UDON SOUTH SITE DEVELOPMENT PLAN 12265 HIGHWAY 94

UDON SOUTH - PCD FILE # PPR2422

ISSUED: 08.23.2024
SITE PLAN
SHEET 3 OF 8

3 SCREENING FENCE
NTS

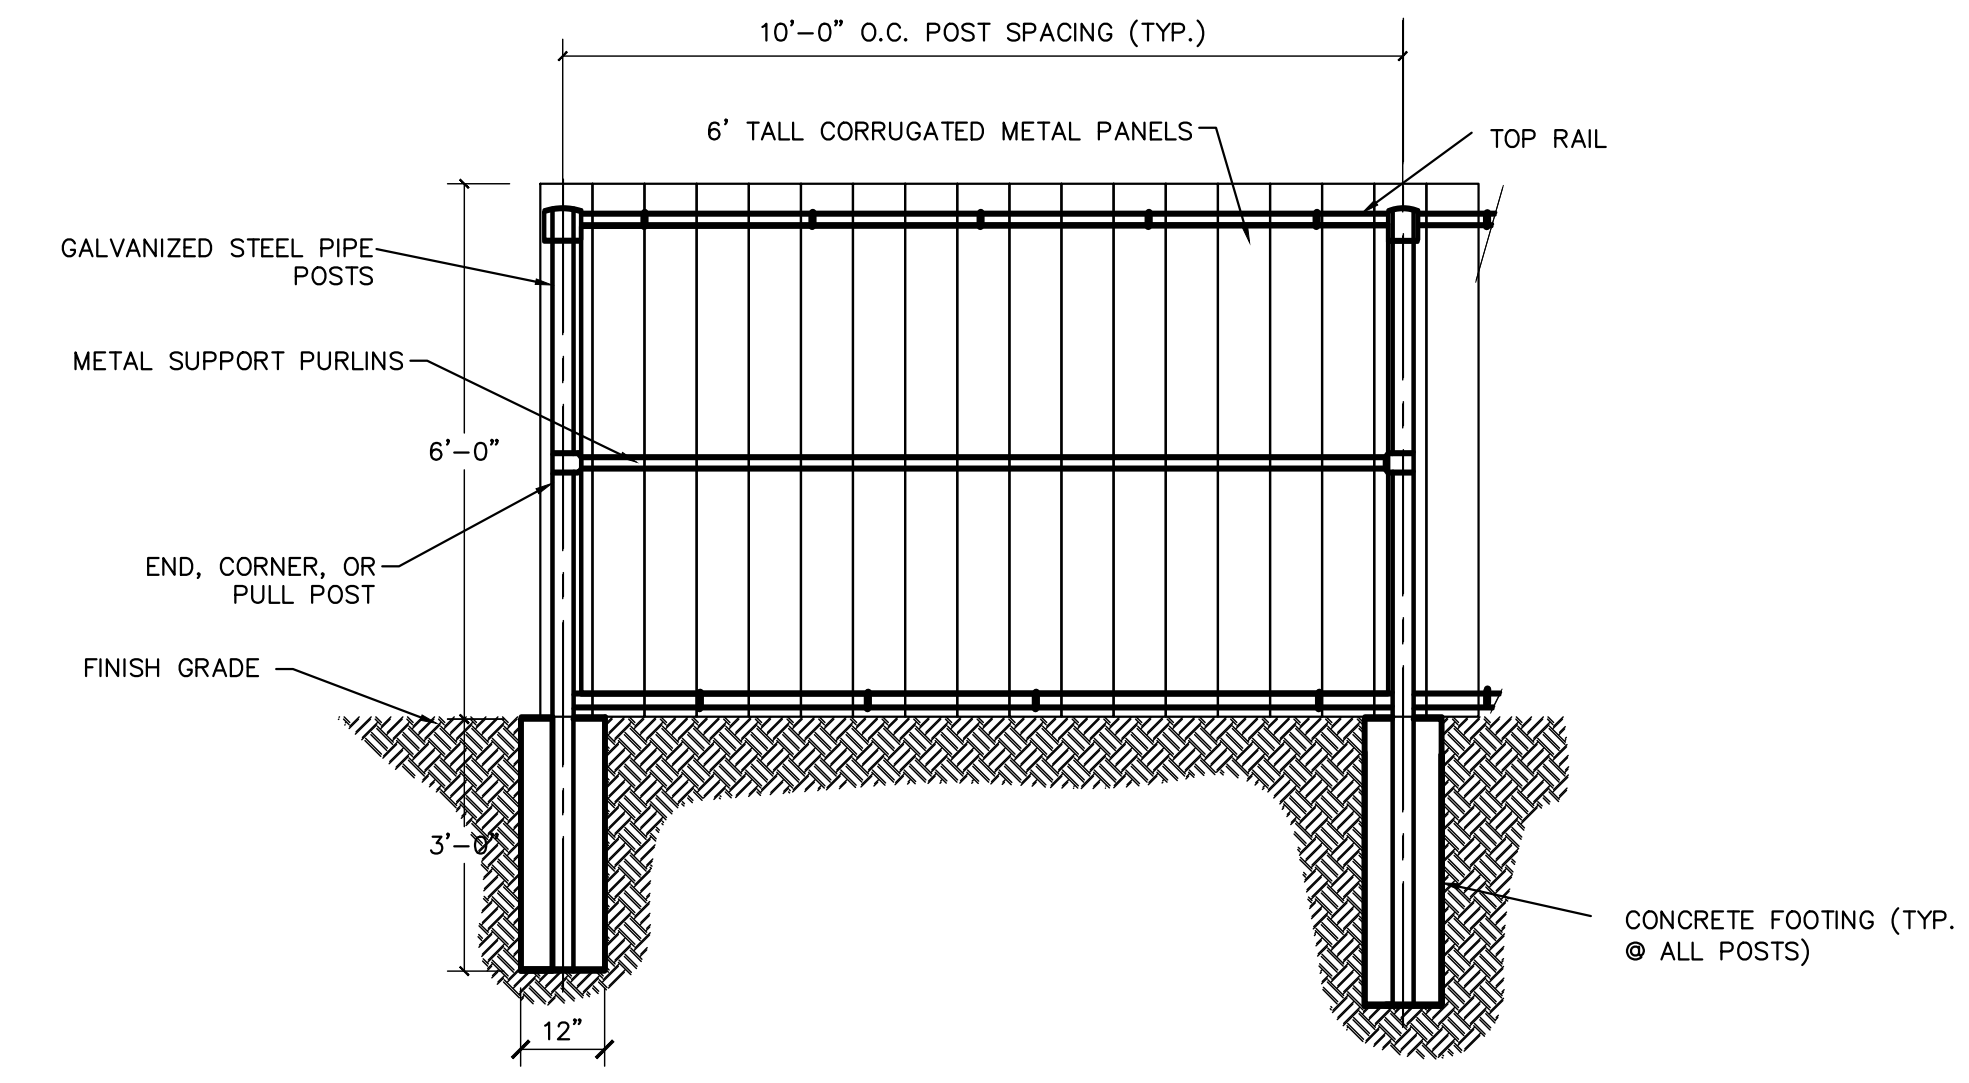
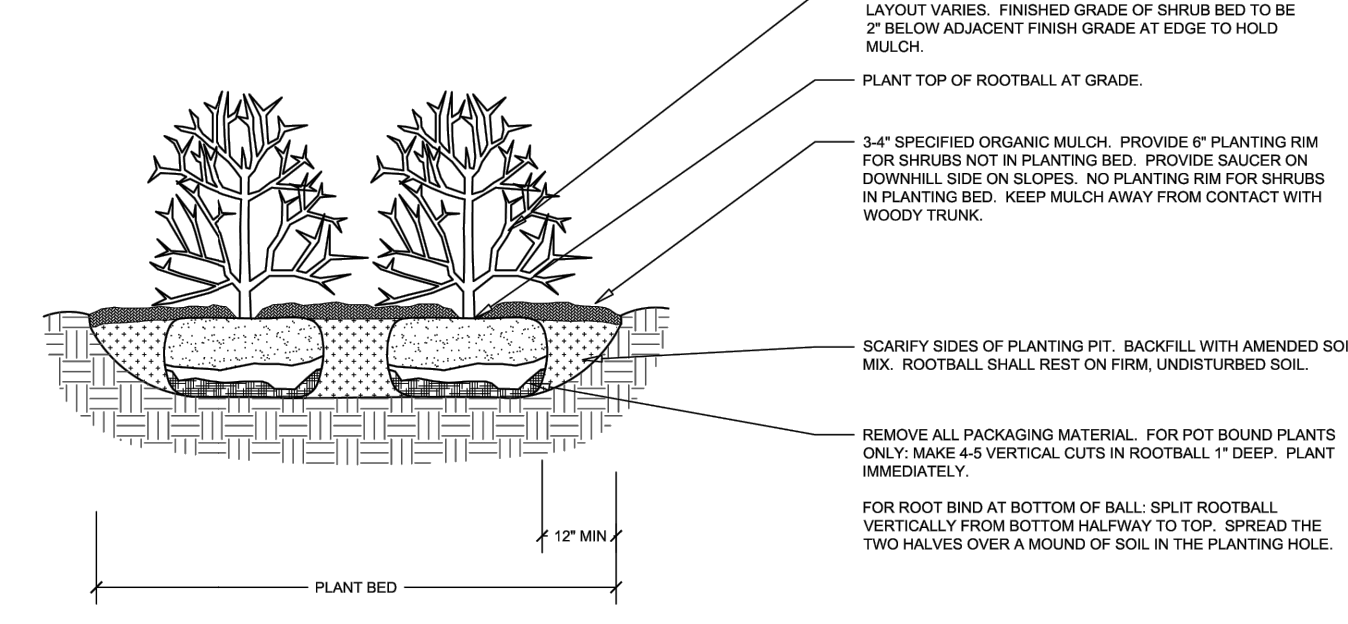
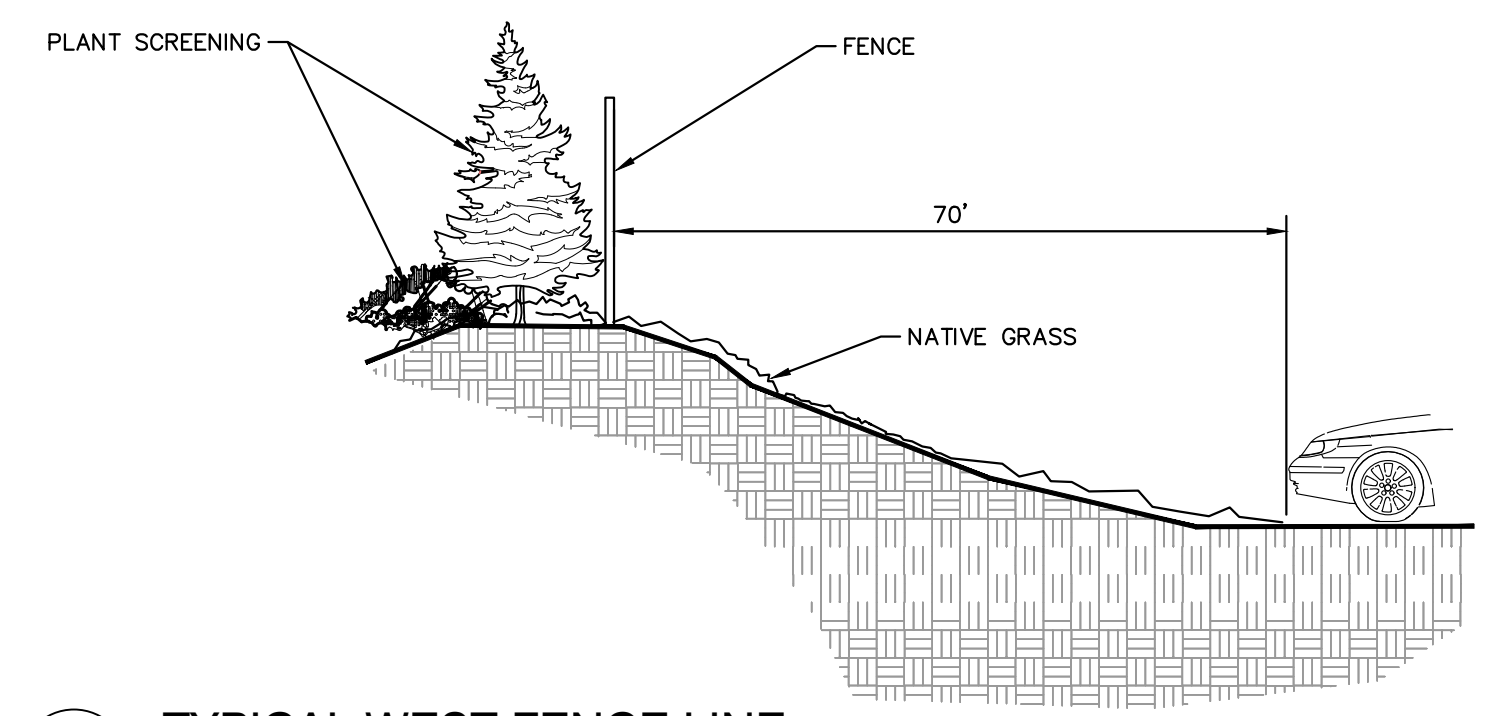
Outside storage shall be enclosed and concealed by a solid fence or wall at least 6 feet in height or any combination of berming, shrubs, trees, fencing or walls which will provide at maturity a minimum of 6 feet of height and 100% opaque screening for the area utilized for outside storage.

You have shown on one fence line that it is the top of landscaping berm. Are all fences on top of berms? How high are the berms? What type of fence material are you using?
